From: [Brenda Larsen](#)
To: [Jeff Watson](#)
Subject: RE: Fiorito (BL-10-00035)
Date: Tuesday, December 07, 2010 11:26:23 AM

Re: Fiorito (BL-10-00035)

Brenda Larsen
Kittitas County Fire Marshal
509-962-7000

Proposed

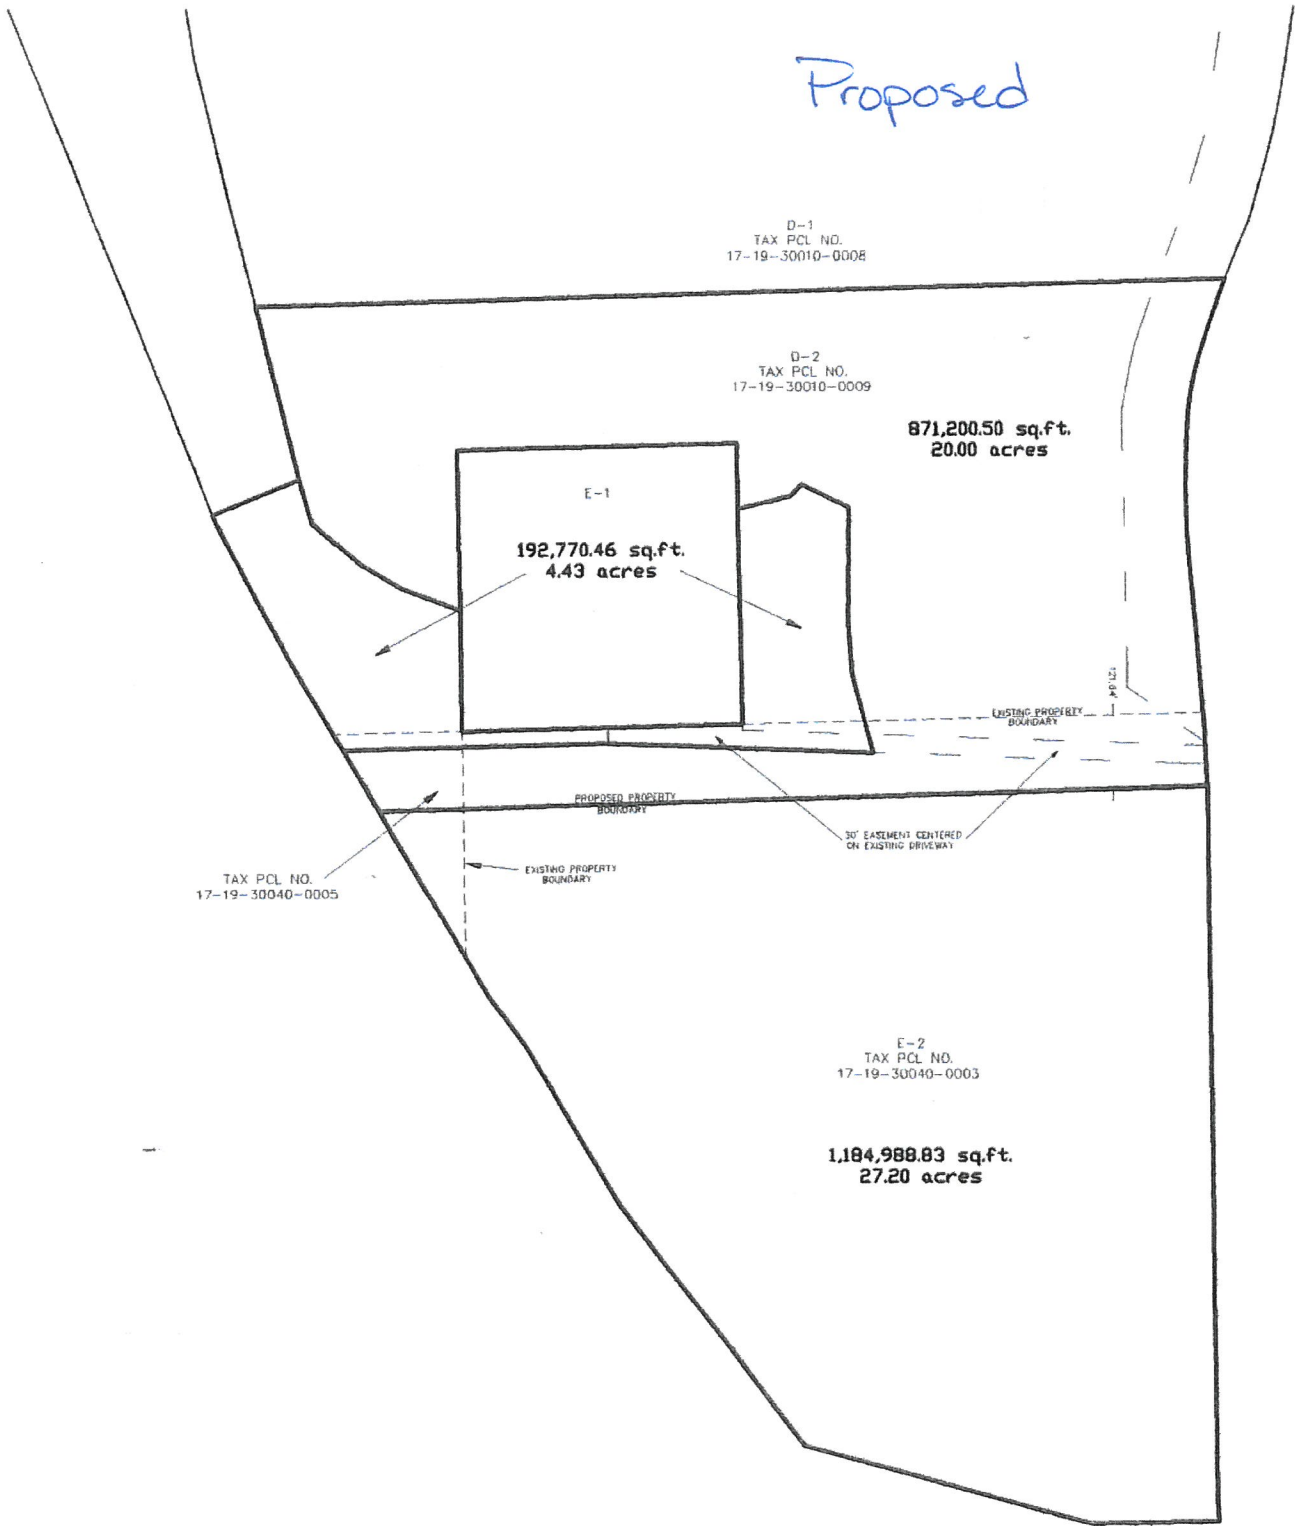
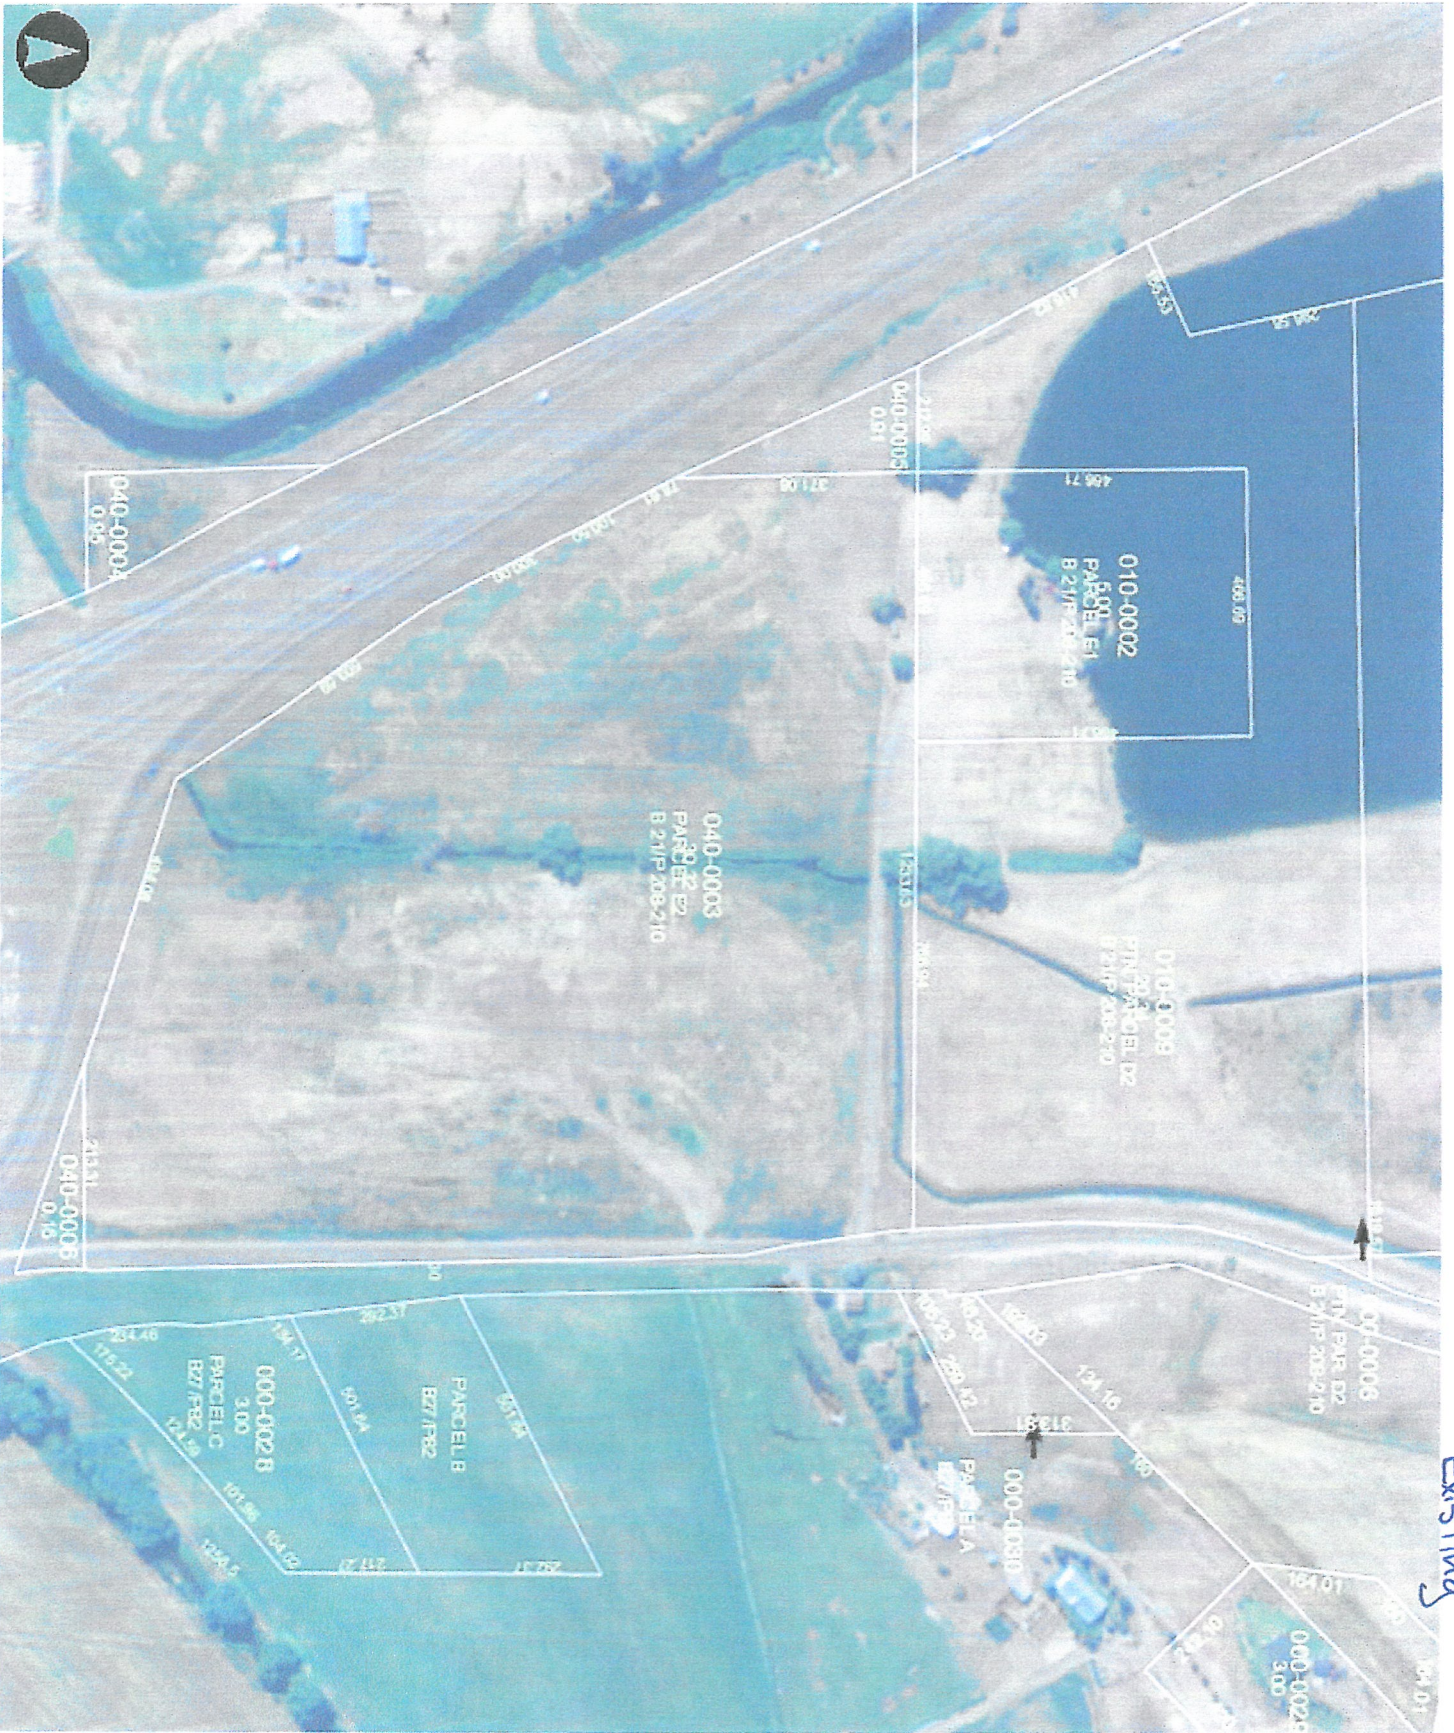
- Ensure that boundary line adjustments do not infringe upon existing structures, to include propane tanks, etc.
- Creation of any additional roads or access must comply with the International Fire Code.
- Additional land use actions as a result of this action may require fire flow.
- All future development must comply with the International Fire Code.
